AKD/KT
14448
10 August 2016

**SECTION 96(1A) - MODIFICATION APPLICATION TO SSD 6952
WENONA SCHOOL**

On behalf of Wenona School Limited, we hereby submit an application pursuant to section 96(1A) of the *Environmental Planning and Assessment Act, 1979* (EP&A Act) to modify Development Consent SSD 6952 relating to the approval of a new educational facility at Wenona School, North Sydney.

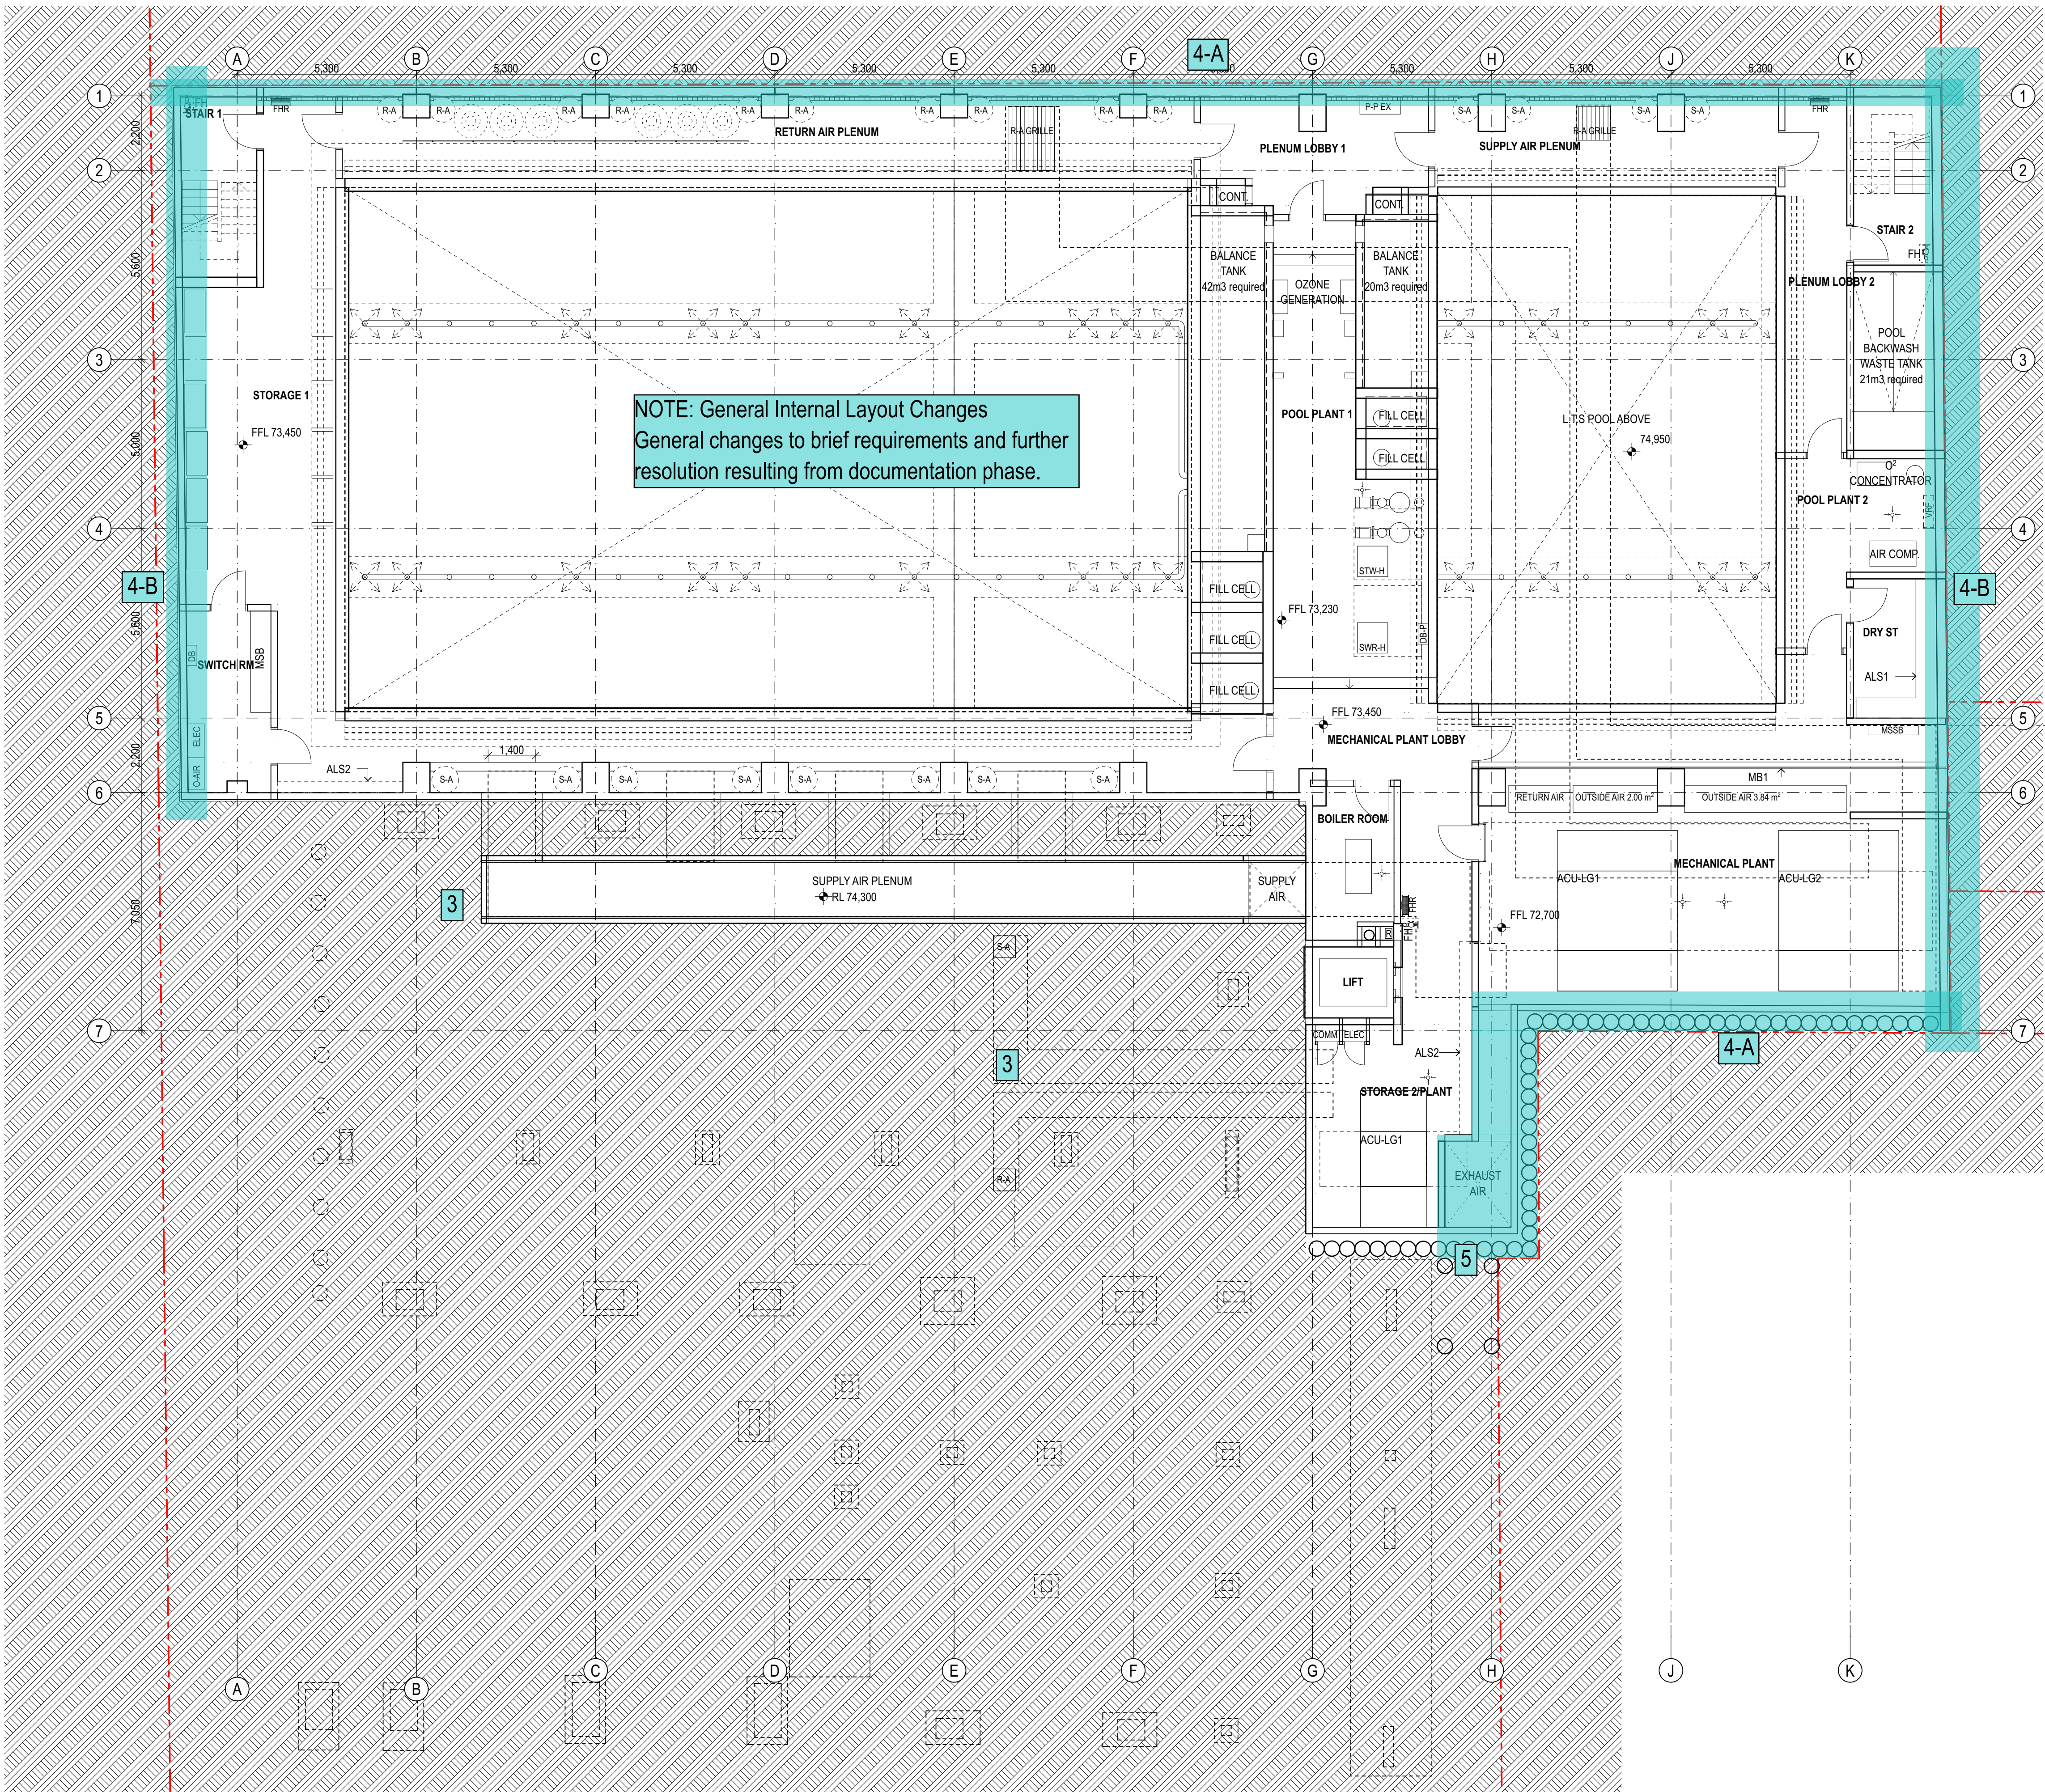
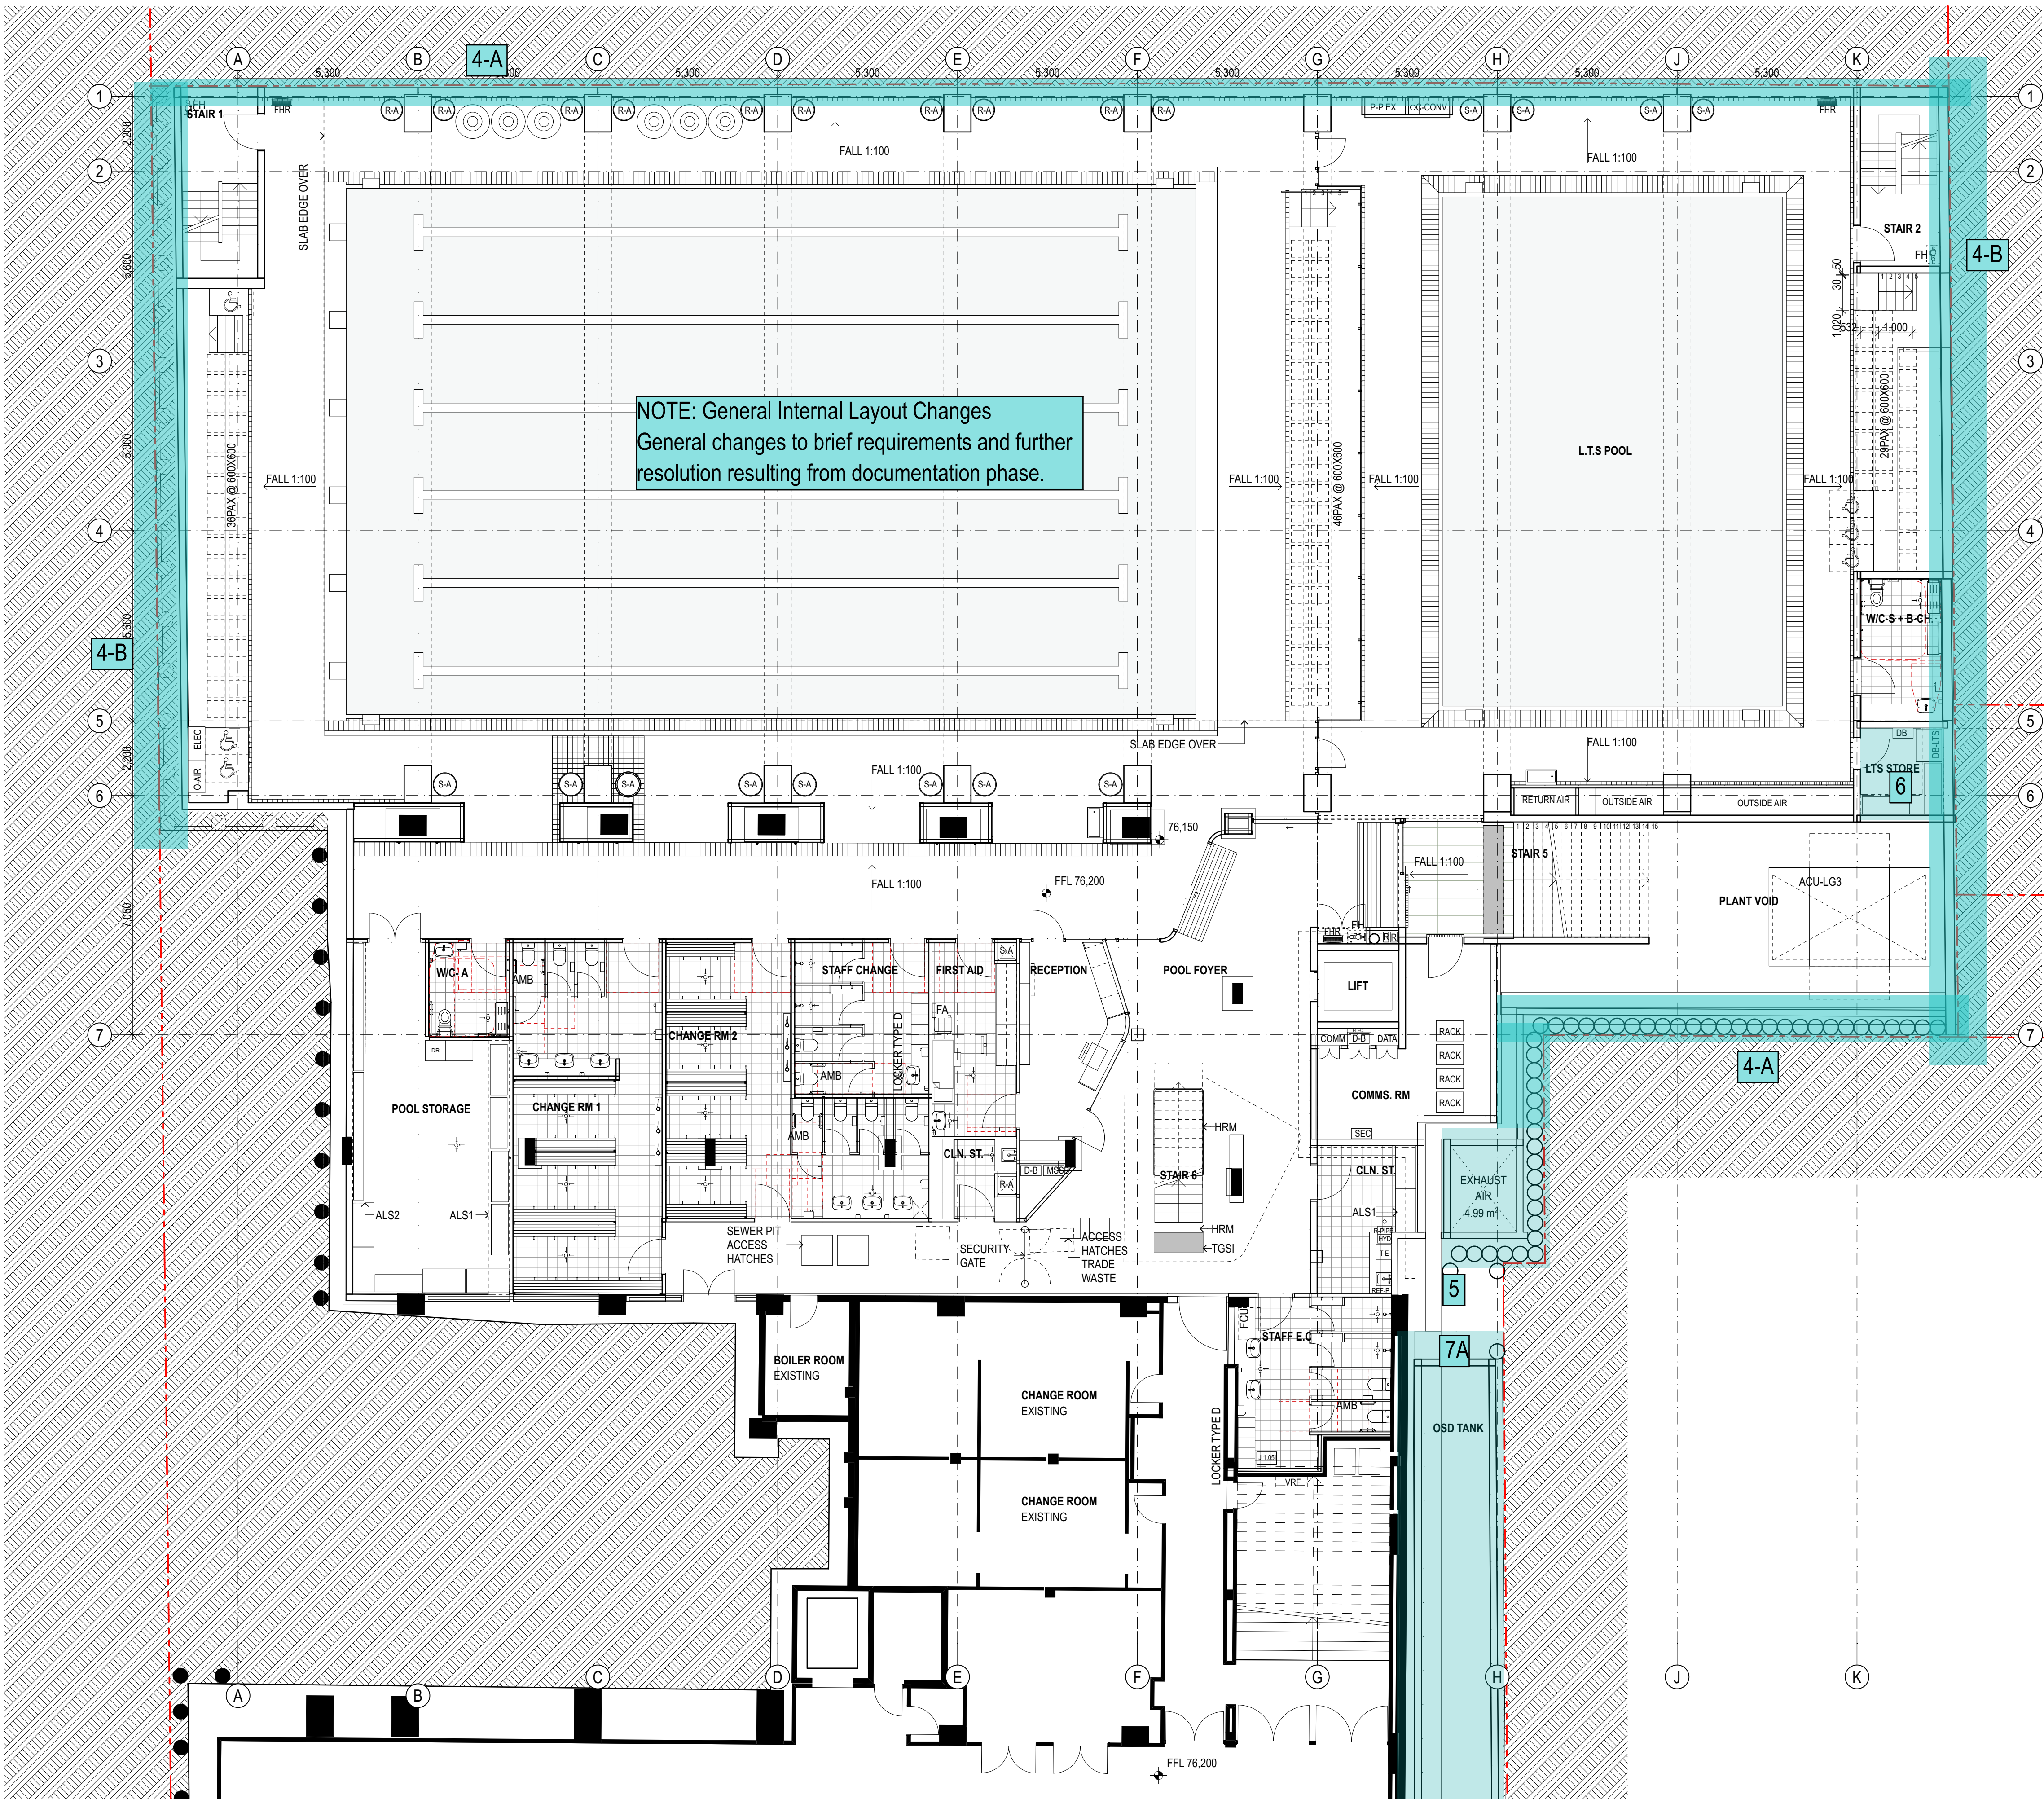
- relocation of the vertical exhaust riser from the eastern side of the building to the southern side of the building;
- correction of the floor to floor heights on Level 4 through to Level 6 due to revised survey information (there will be no change to the approved height);

- amendments to the shoring system, underpinning of the neighbouring properties and increase to the extent of the mechanical trenching;
- design development of the building's Miller Street façade to remove surplus louvres over the timber balustrade to provide a consistent presentation of the balcony frontages;

Level	Description of Proposed Modification	Drawing No.	Revision
Approved Name / Proposed Name			
Lower Ground Floor 3 / Level 0	<ul style="list-style-type: none"> ■ relocation of the vertical exhaust riser from the eastern side of the building to the southern side of the building. ■ amendments to the internal layout of the pool plant room including; <ul style="list-style-type: none"> - relocation of two (2) balance tanks; - inclusion of a boiler room; - addition of a partition wall; - and reconfiguration of the entrance; 	A – 1002	A

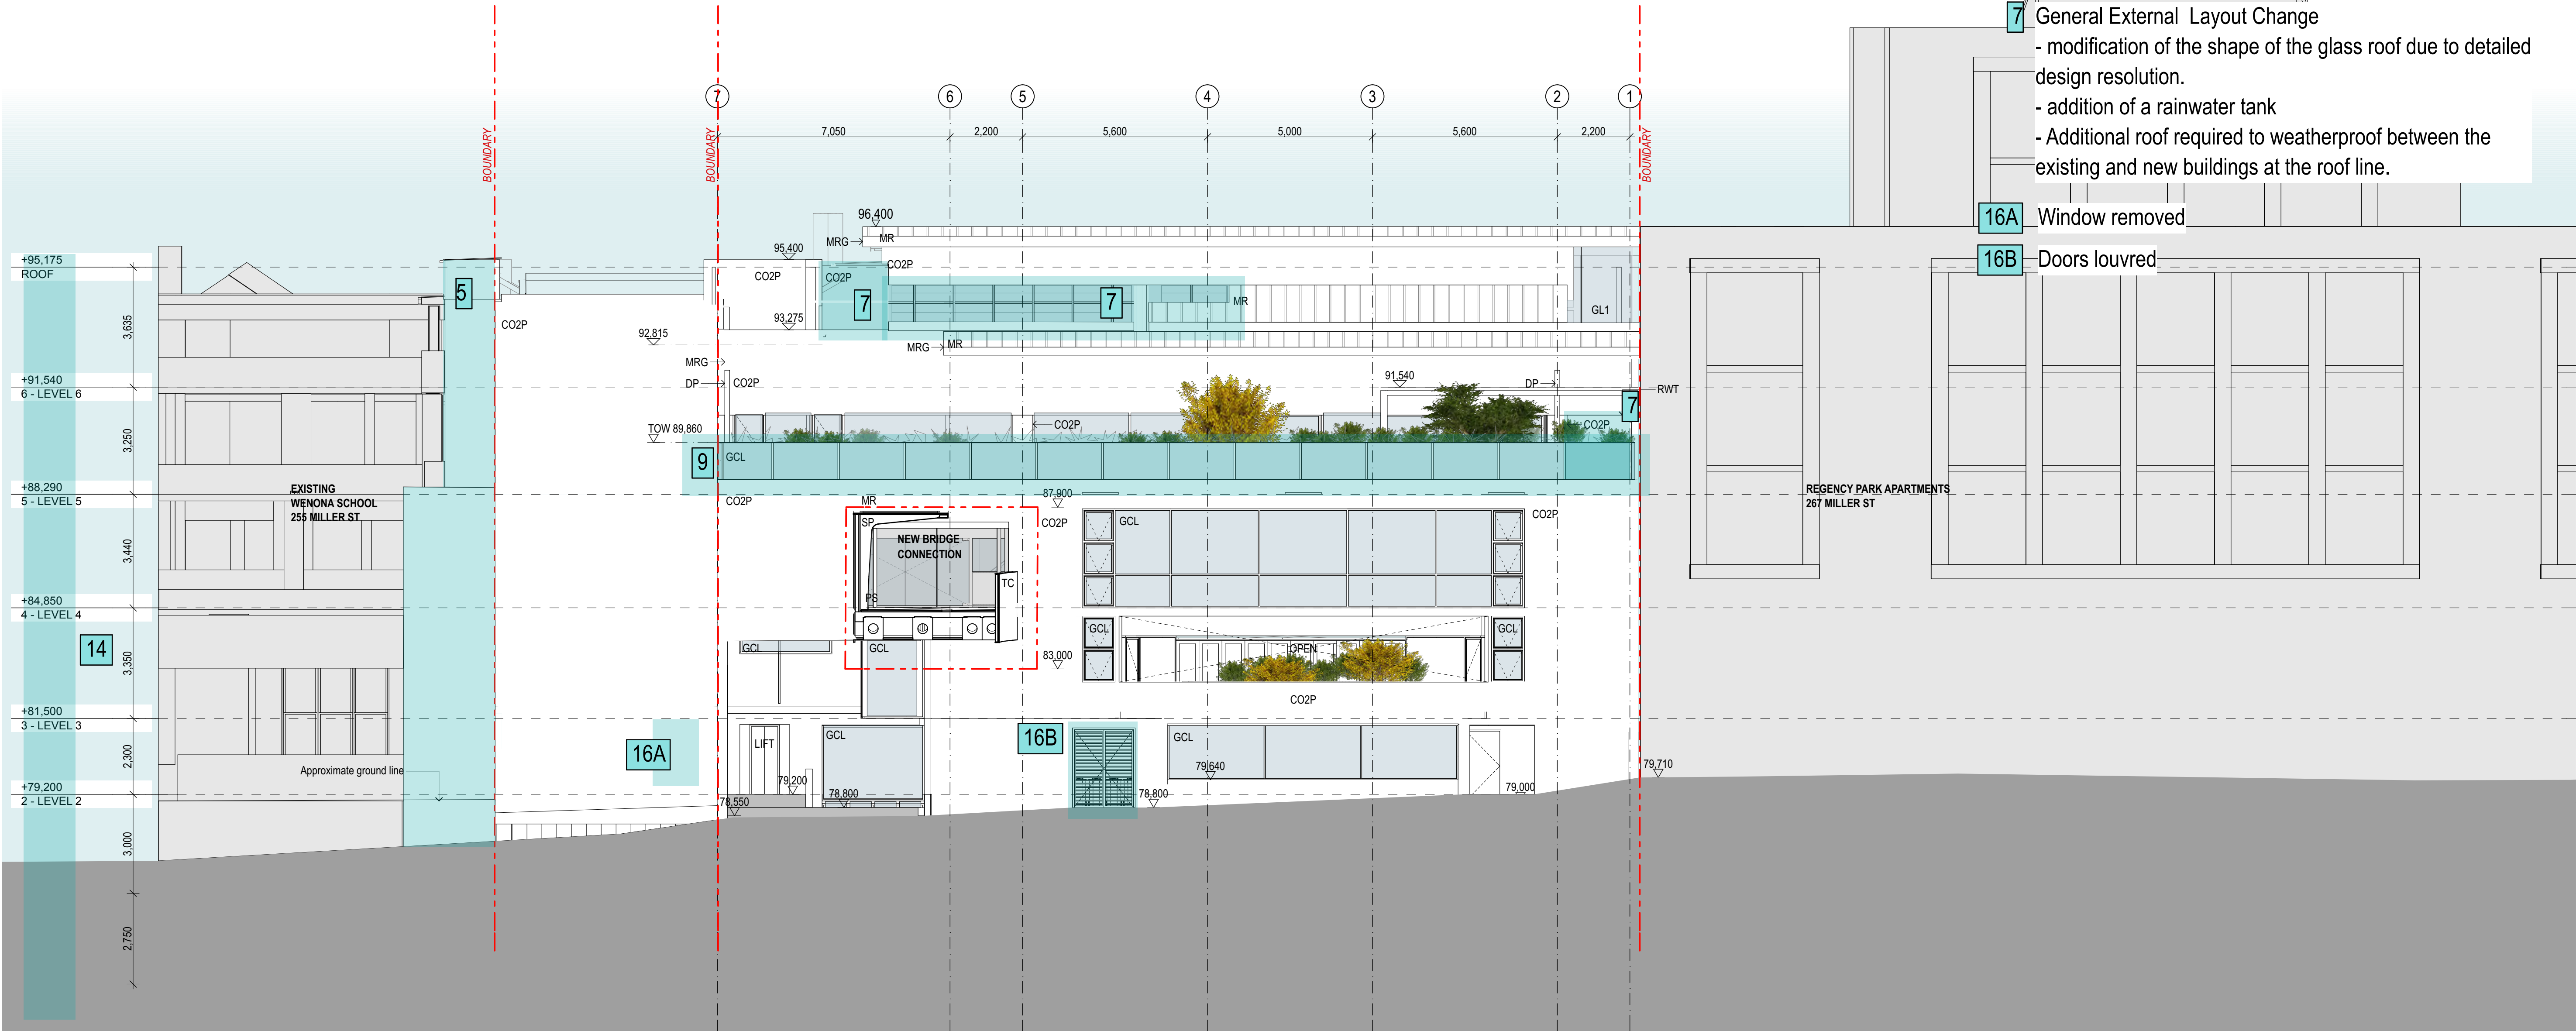
Level Approved Name / Proposed Name	Description of Proposed Modification	Drawing No.	Revision
	<ul style="list-style-type: none"> minor amendments to the layout of the "Senior Ecosystem". 		
Roof Plan	<ul style="list-style-type: none"> increase in the size of the roof plant by approximately 40m²; amendment to the configuration of the glass roof; and minor changes to the roof type and pitch. 	A – 1009	A
Elevation Miller Street	<ul style="list-style-type: none"> minor amendments to the RLs floor to floor levels; and inclusion of three (3) entrance doors to the fire hydrant / booster system. 	A – 2001	A
Elevation Elliott Street	<ul style="list-style-type: none"> minor correction of RLs of the floor to floor levels in response to survey details; conversion of the concrete balustrade fronting the Elliott Street to a concrete planter wall with glass balustrade with a total height of 1570mm; reconfiguration to the layout of the glass roof; and removal of the window located on Level 3 / Lower Ground 1. 	A – 2002	A

- relocation of the vertical exhaust riser from the eastern side of the building to the southern side of the building to reduce the visual impact of the riser on the building's Elliott Street elevation;
